STIP A-0009CA

Concurrence Point 4B Hydraulic Design Review Meeting Minutes

Subject: STIP No. A-0009CA, Graham County
Concurrence Point 4B Virtual Meeting

Purpose: The purpose of the meeting was to review and discuss the 30% drainage plans for STIP A-0009CA. The project goes from Robbinsville to Stecoah.

DETAIL 2
RIP-RAP AT EMBANKMENT
(Not to Scale)

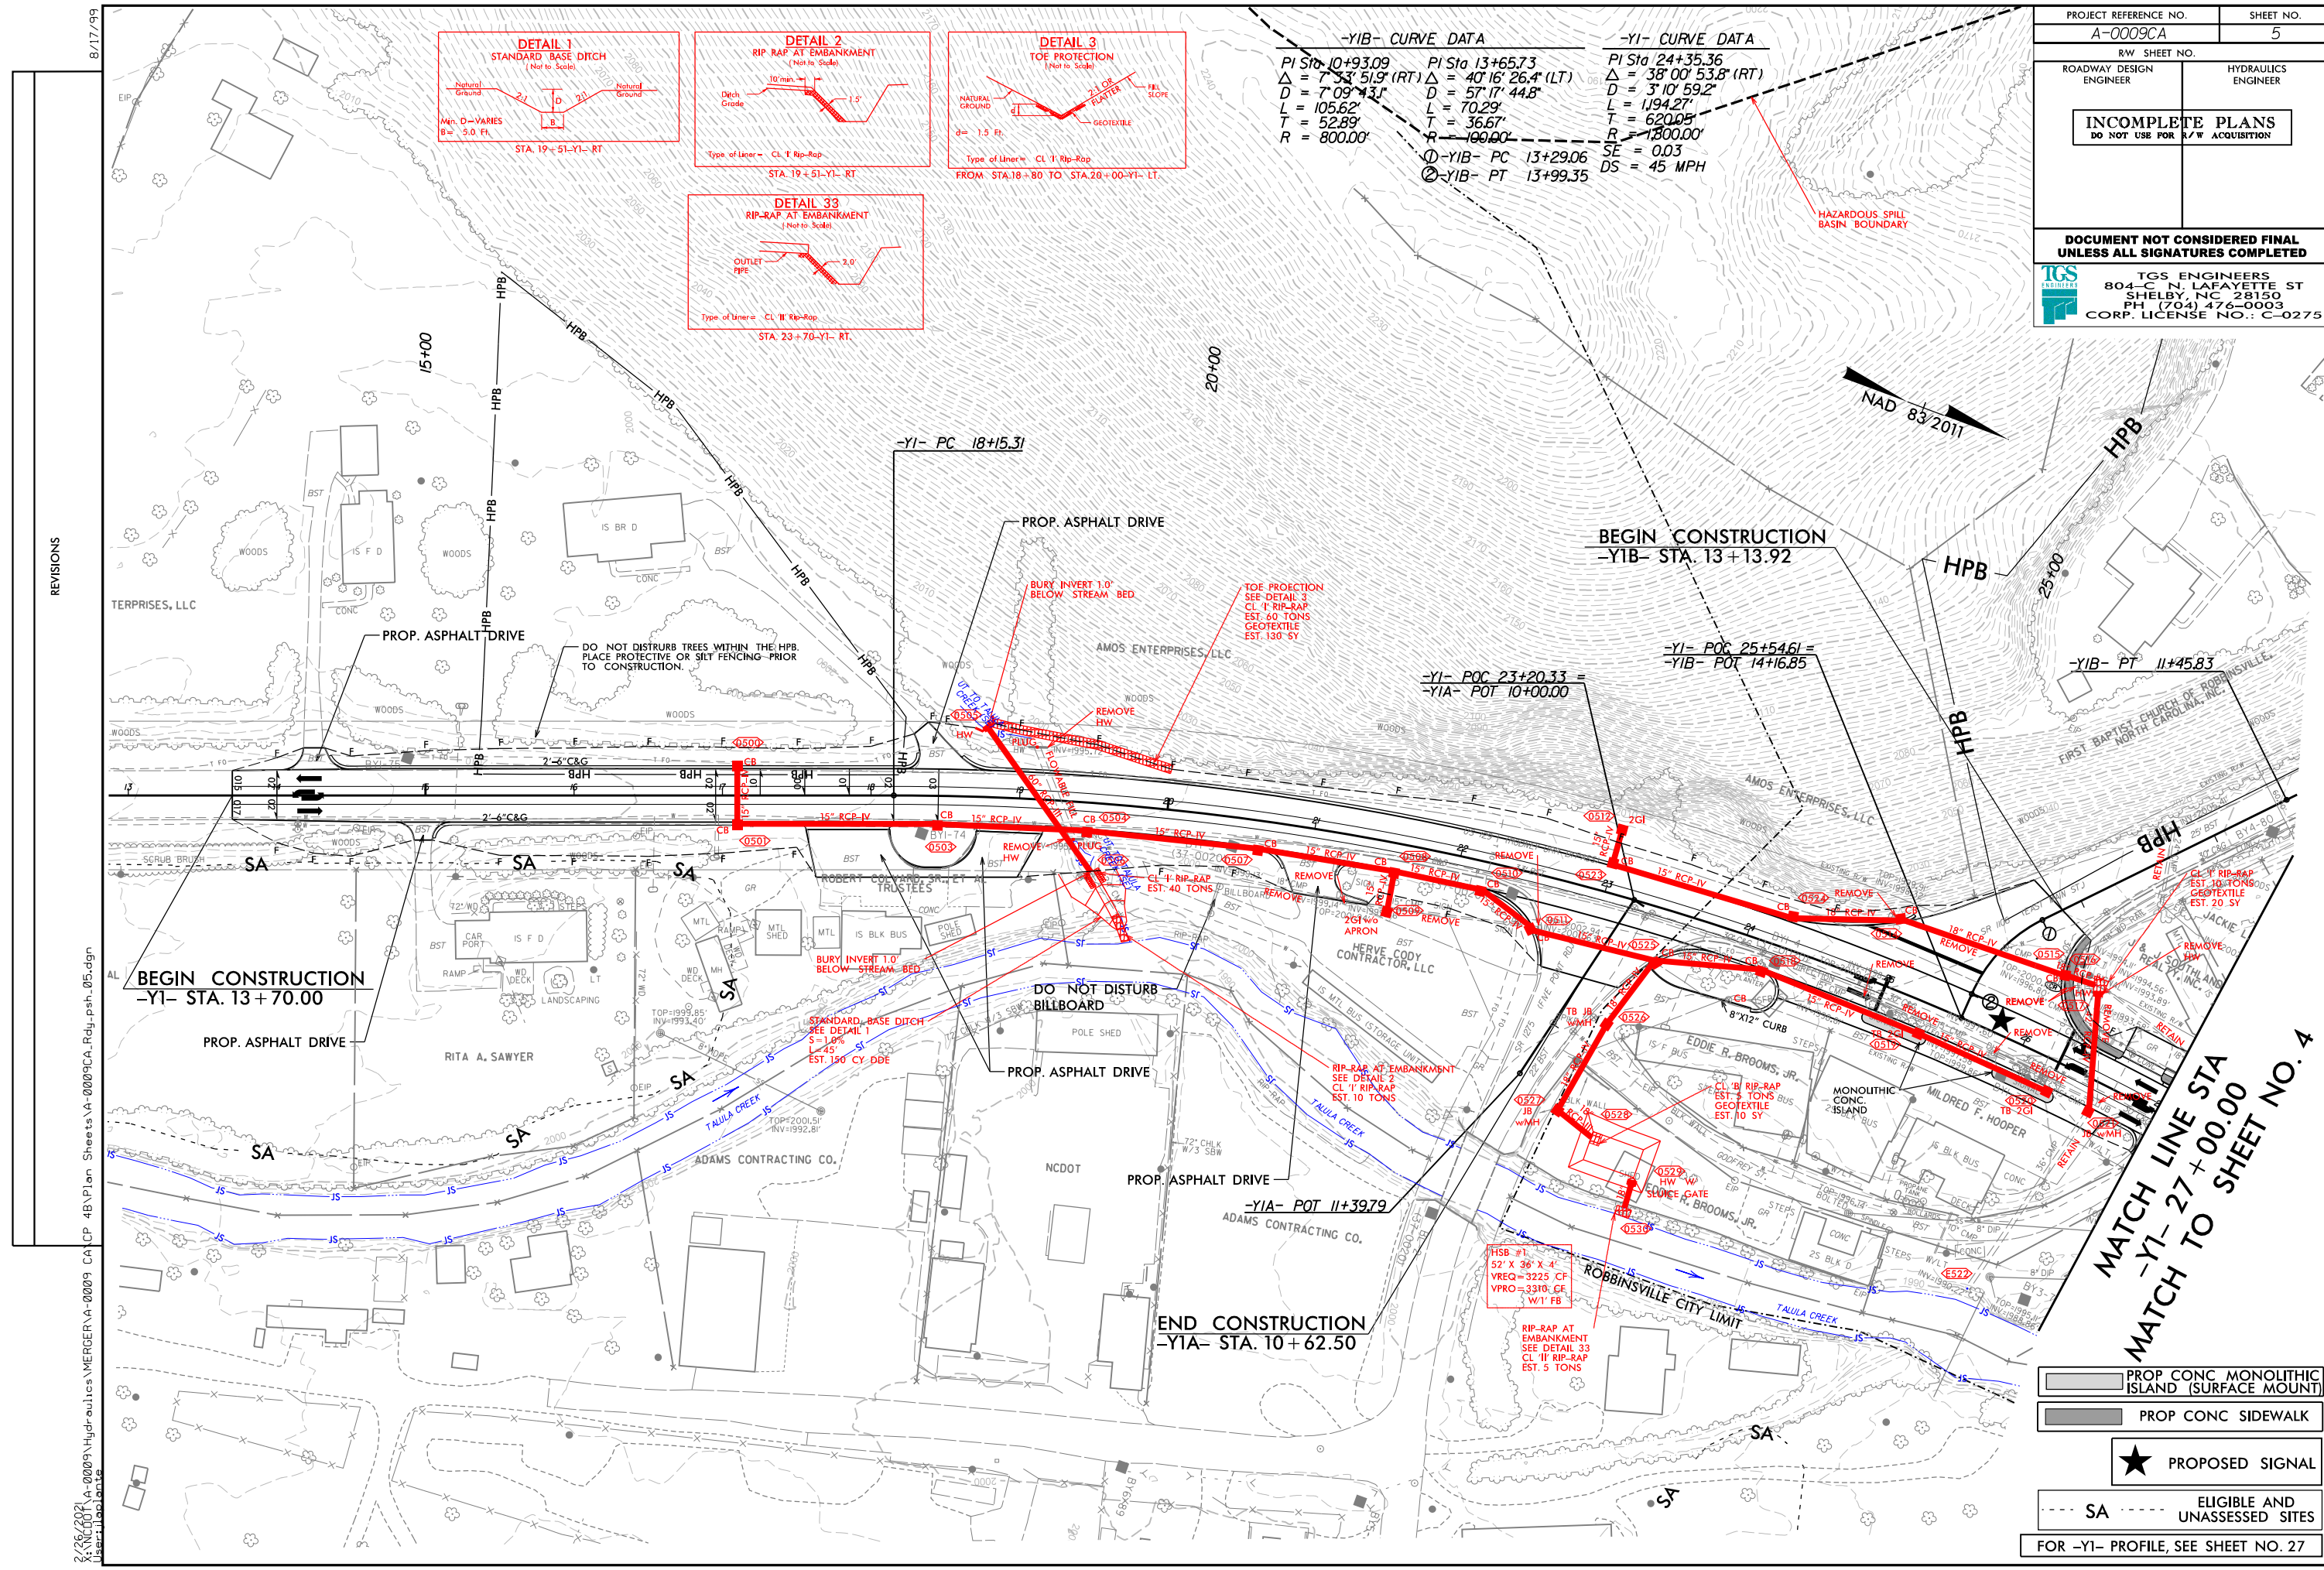
- Crystal suggested reevaluating details for the stream outlet to ensure that the details reflect existing stream dimensions on outfalls. She recommended omitting the word "ditch" from the details for clarity.

- Crystal identified that there is no rip rap shown in stream outlet detail (Detail 1) and requested that rip rap be shown only on banks and embedded, and not in stream bed.

- Robert Patterson and Kevin Mitchell requested that Detail 2 show the tributary with channel dimensions and embedded rip rap. The detail should include a note that the rip rap is keyed in.

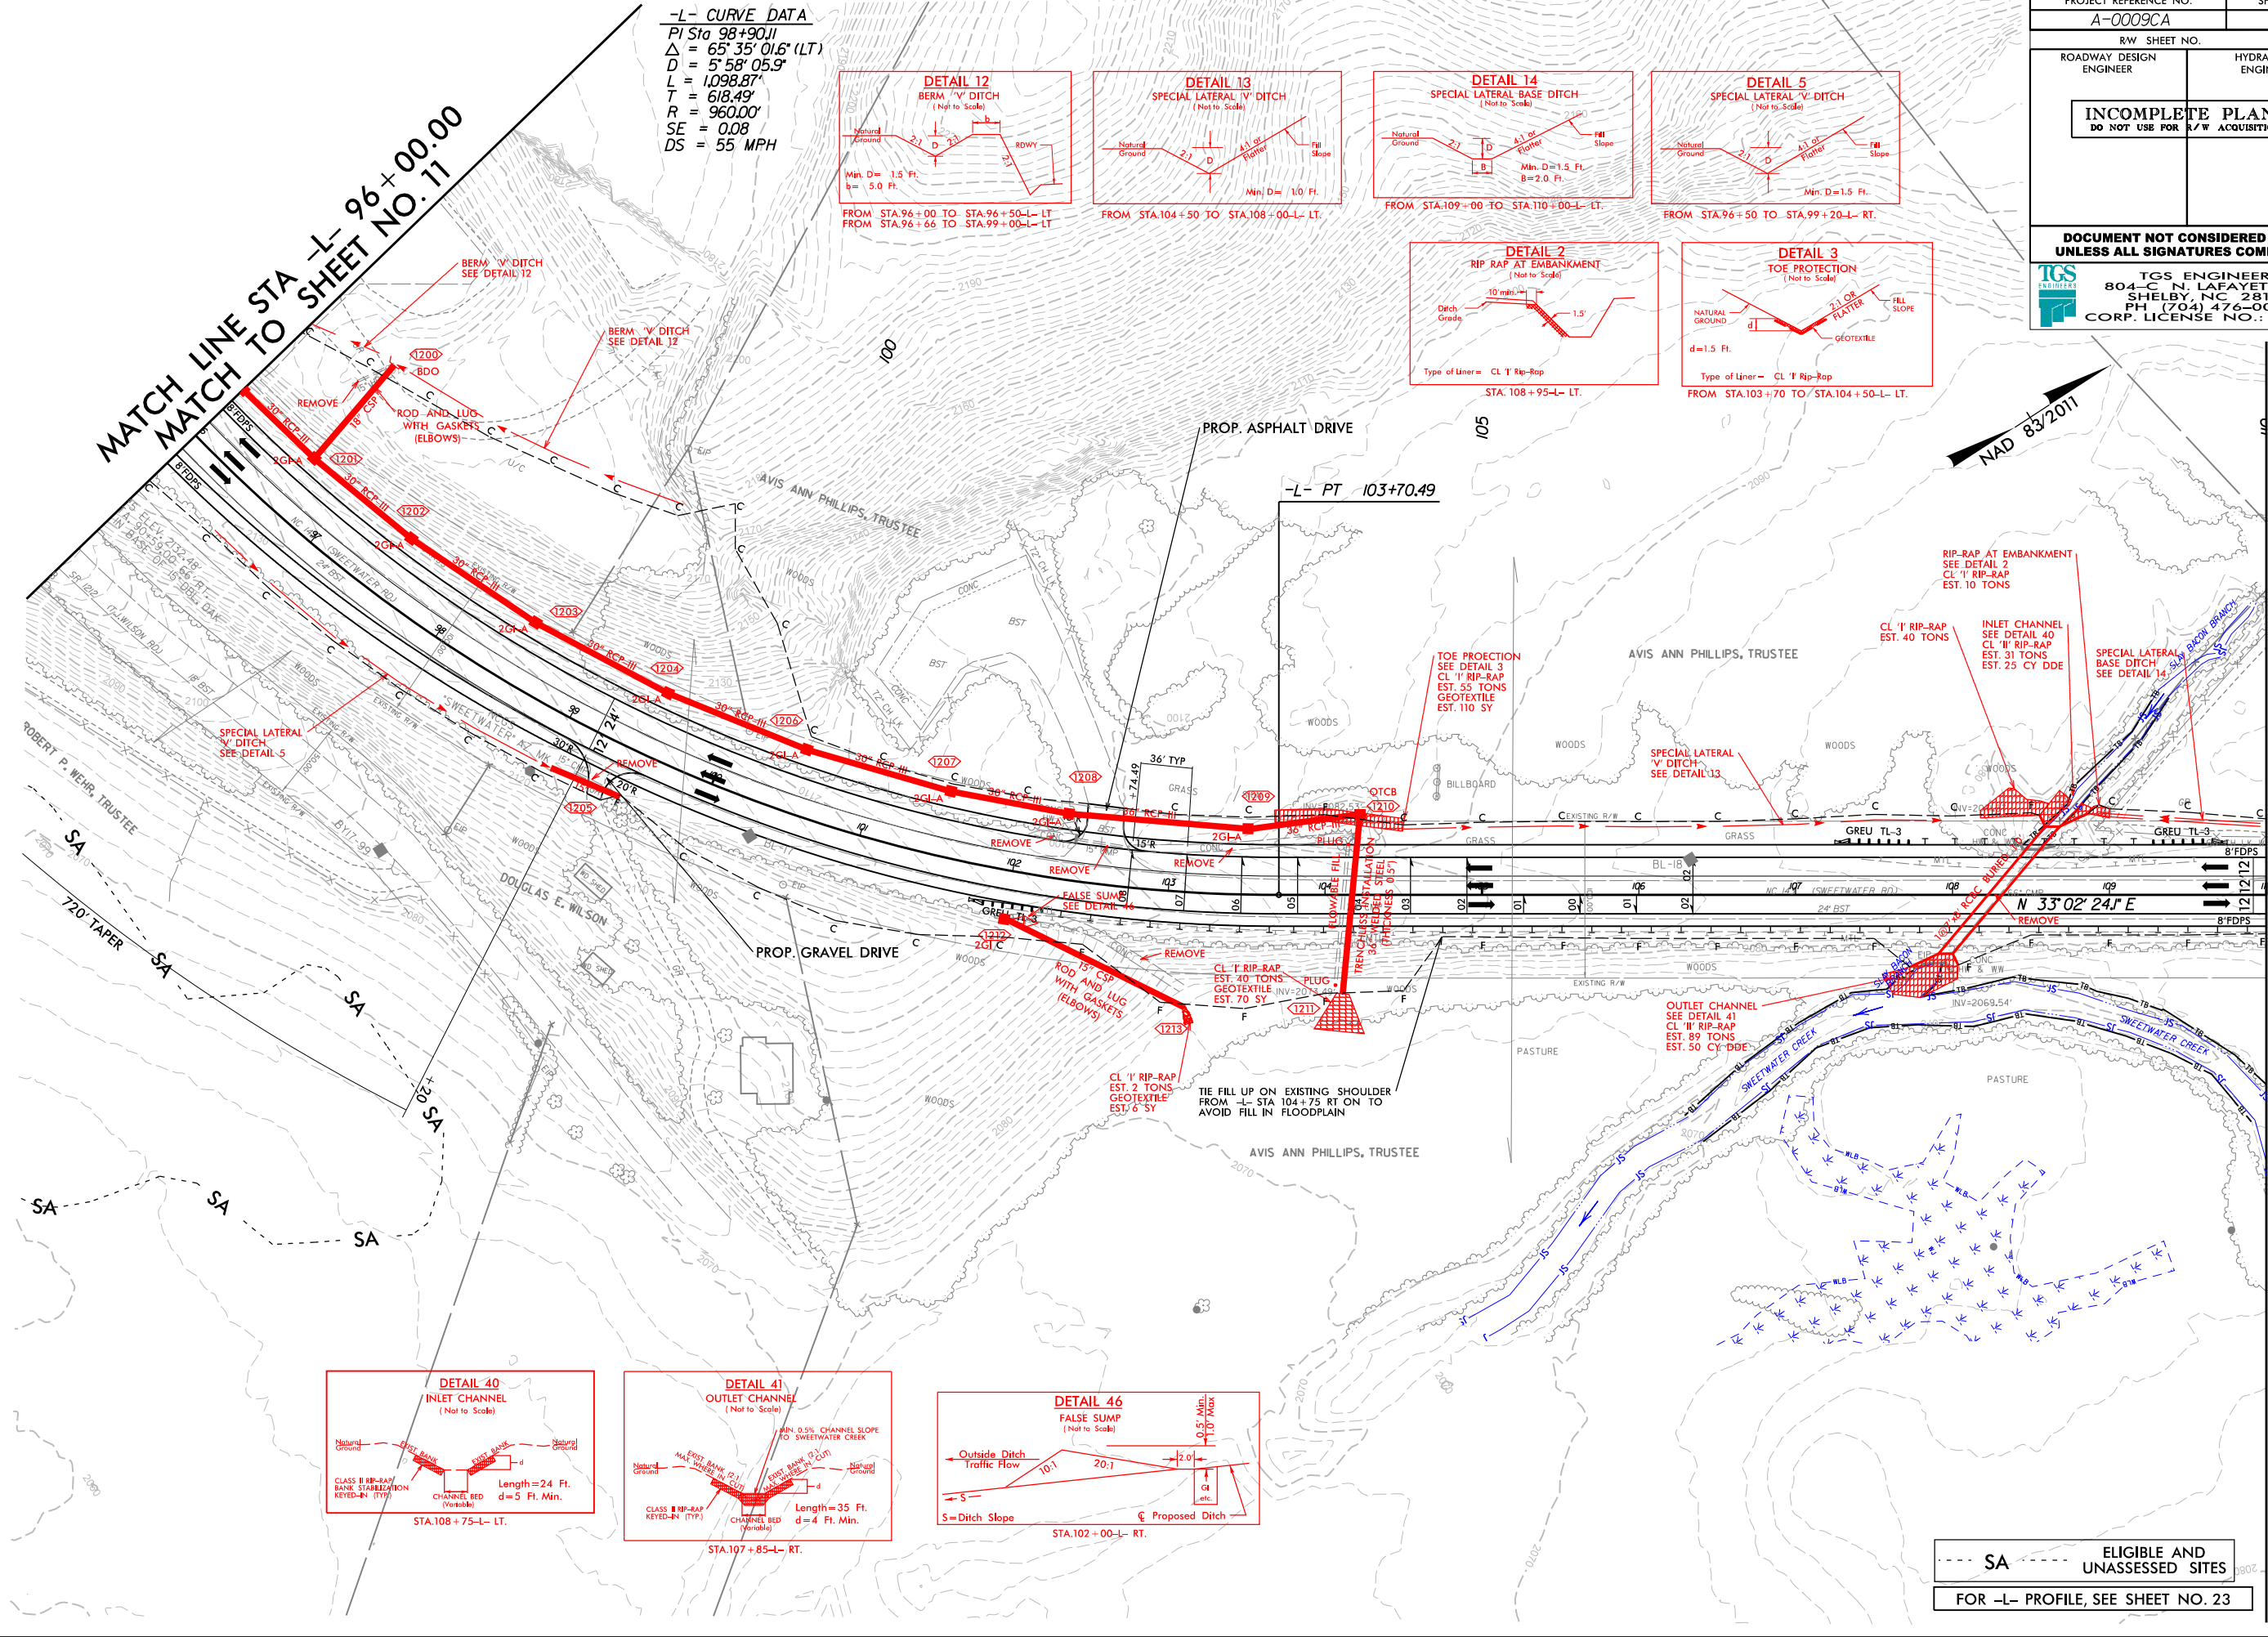
Impacted jurisdictional features on this sheet include the crossing of Slay Bacon Branch (WS-III) at L 108+30. The existing structure is a 66" CMP with a 1' deep scour hole at the outlet. It will be replaced with a proposed 7'x8' RCBC buried 1' with sills and baffles. A temporary onsite detour will be located upstream at crossing. There were no comments on this plan sheet.
